## MEMORANDUM

**Subject:** Application ID: 2015-027

**Date:** 3/23/2015

**Comments Submitted by: Bruce Hyman/Parks on 3/10/2015**

PRELIMINARY - NOT FOR CONSTRUCTION

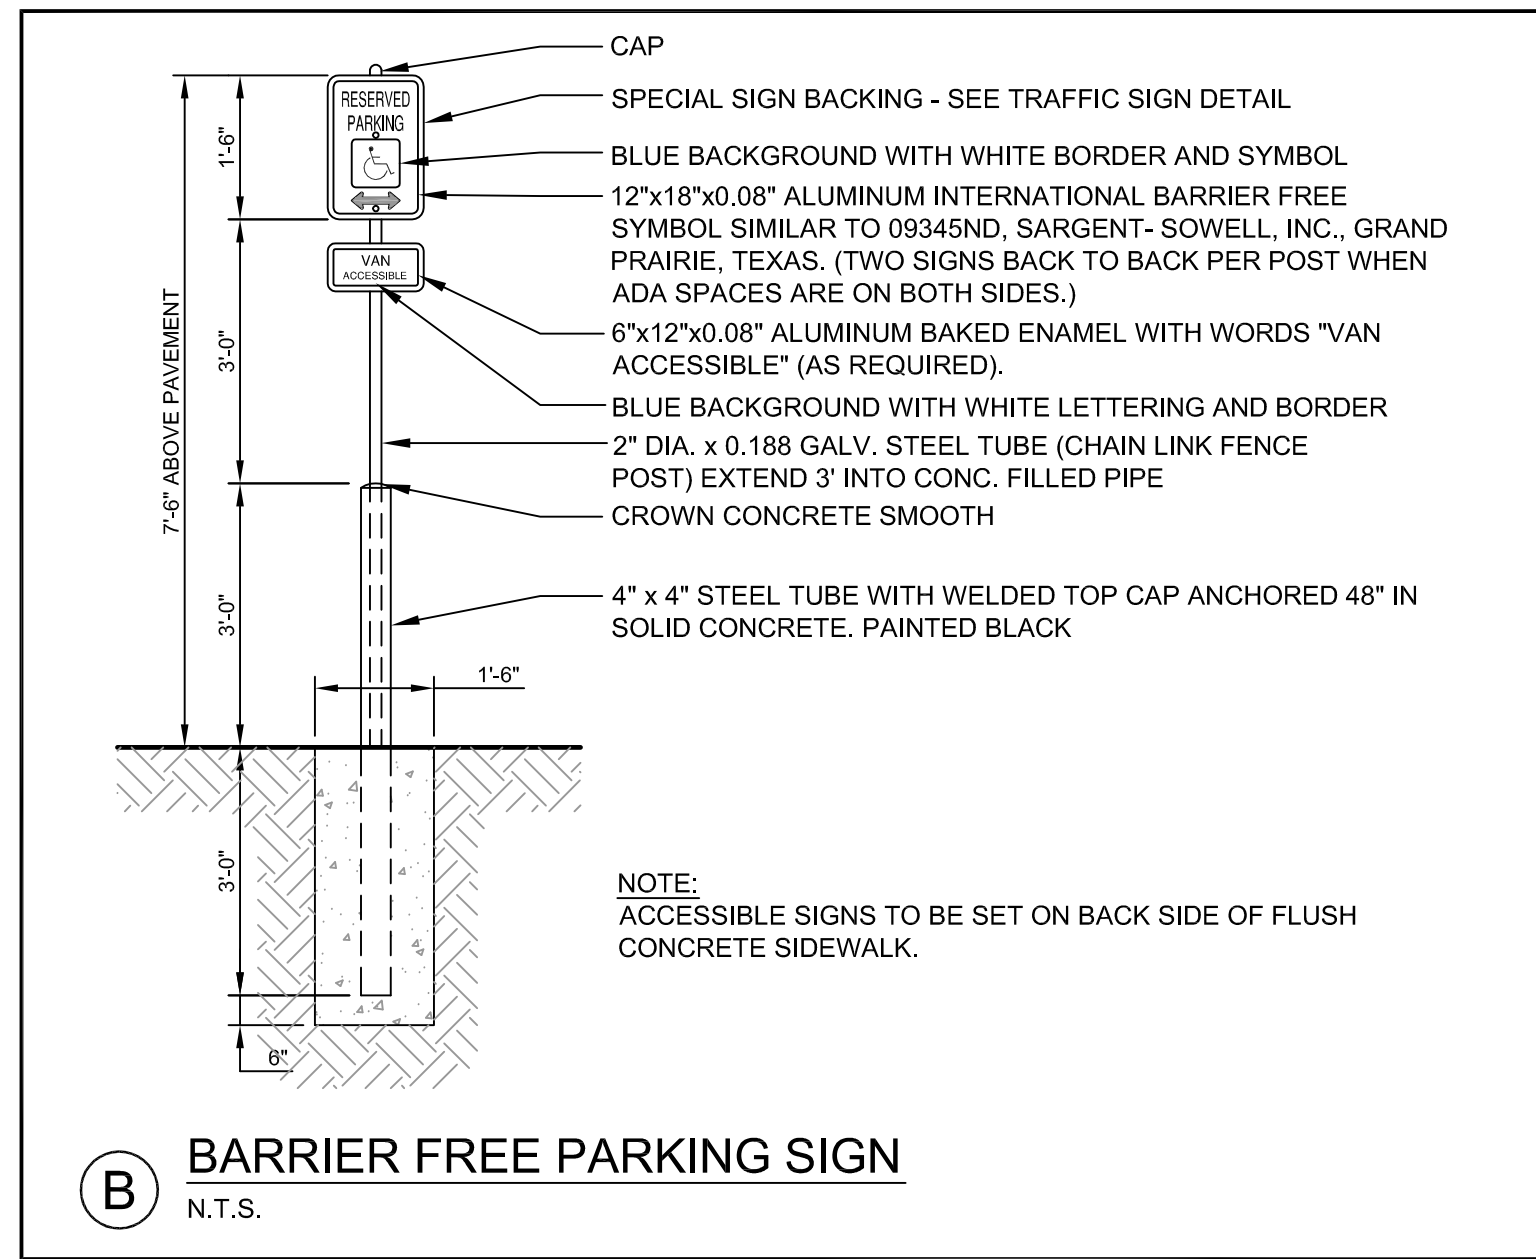
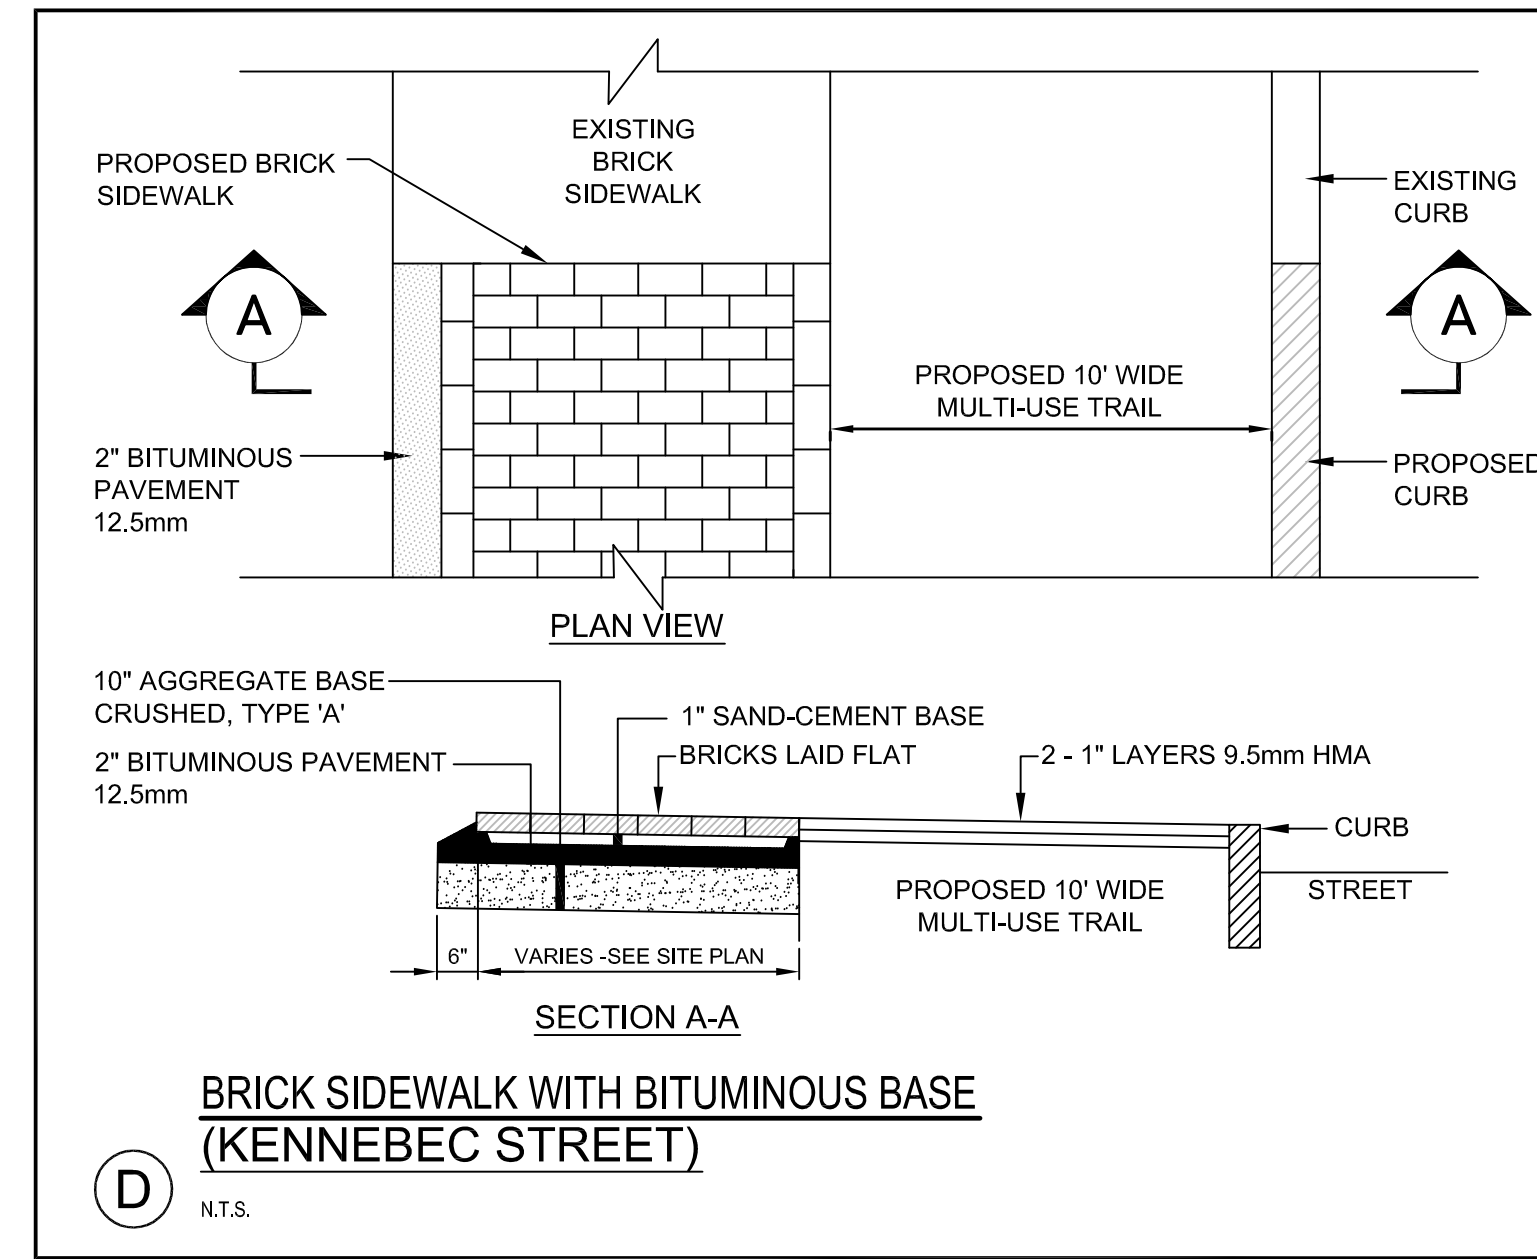
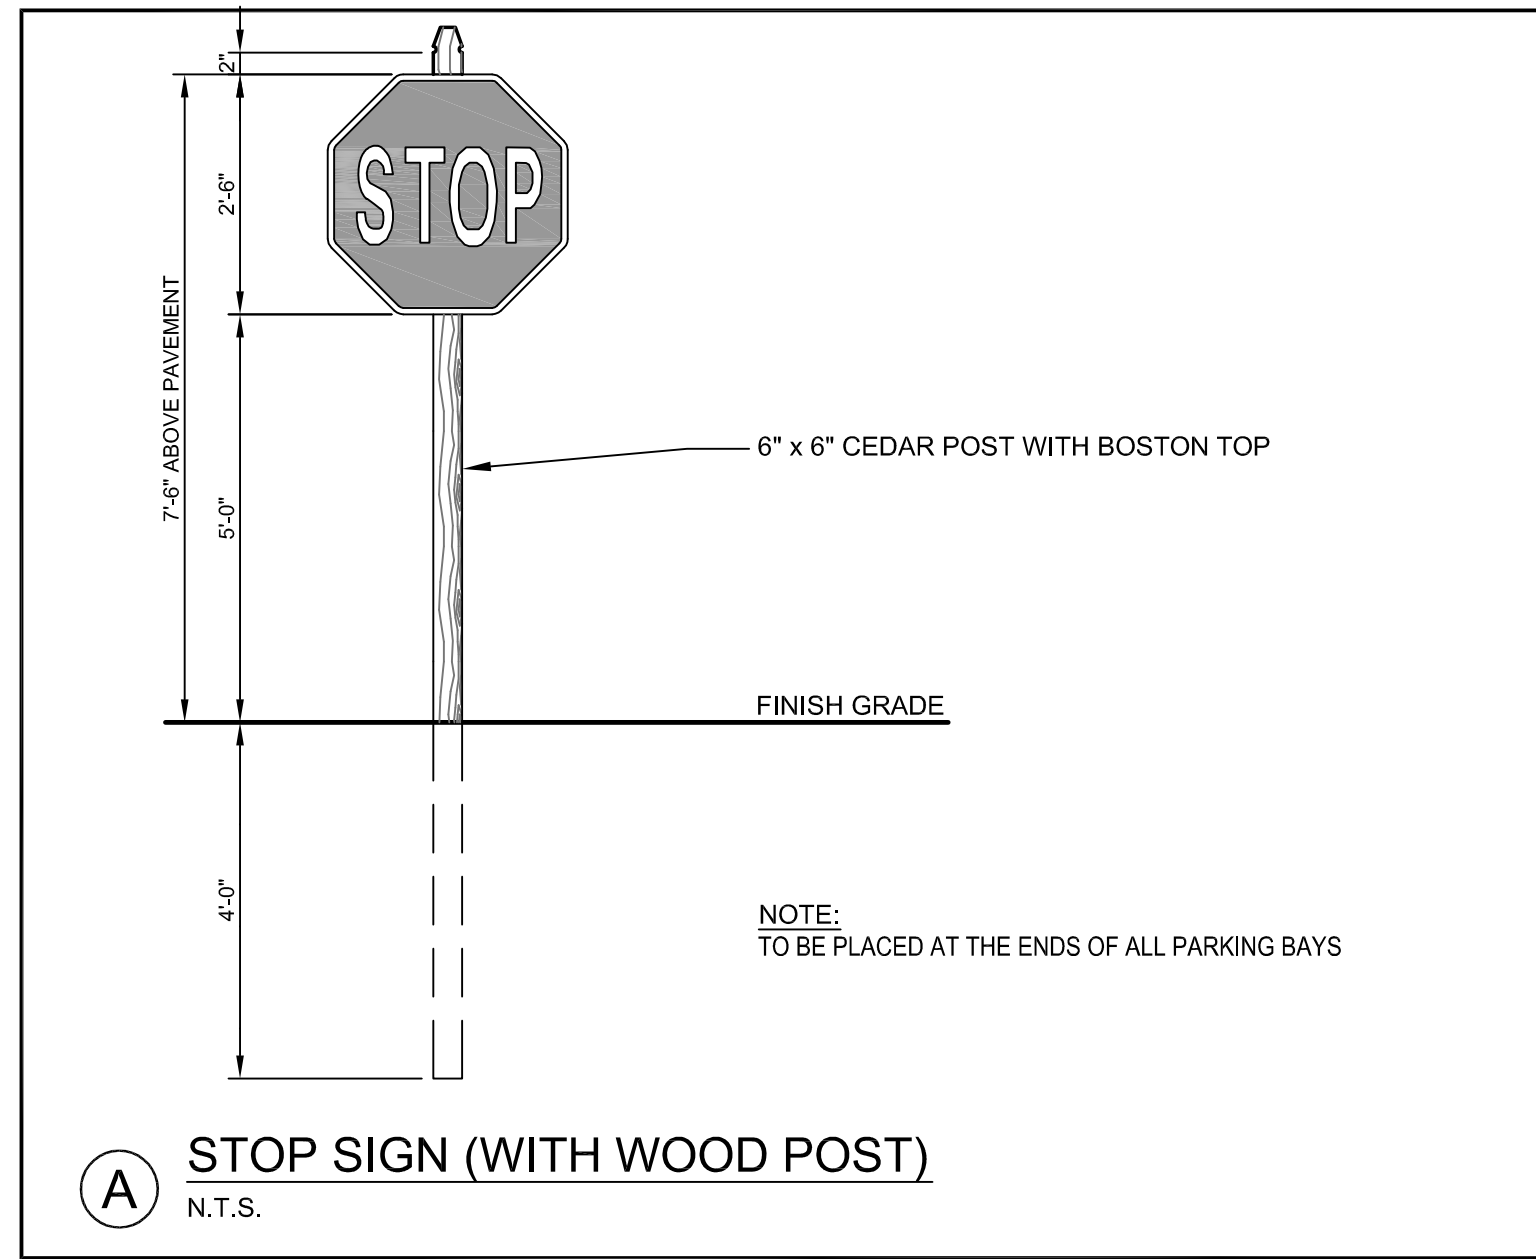
\*\* The bike parking concrete pads should be a minimum of 8' in length and 6' in width (9'x6' better) to ensure their functionality - it's a little hard to scale accurately from the 11x17 plans - they may be that already.
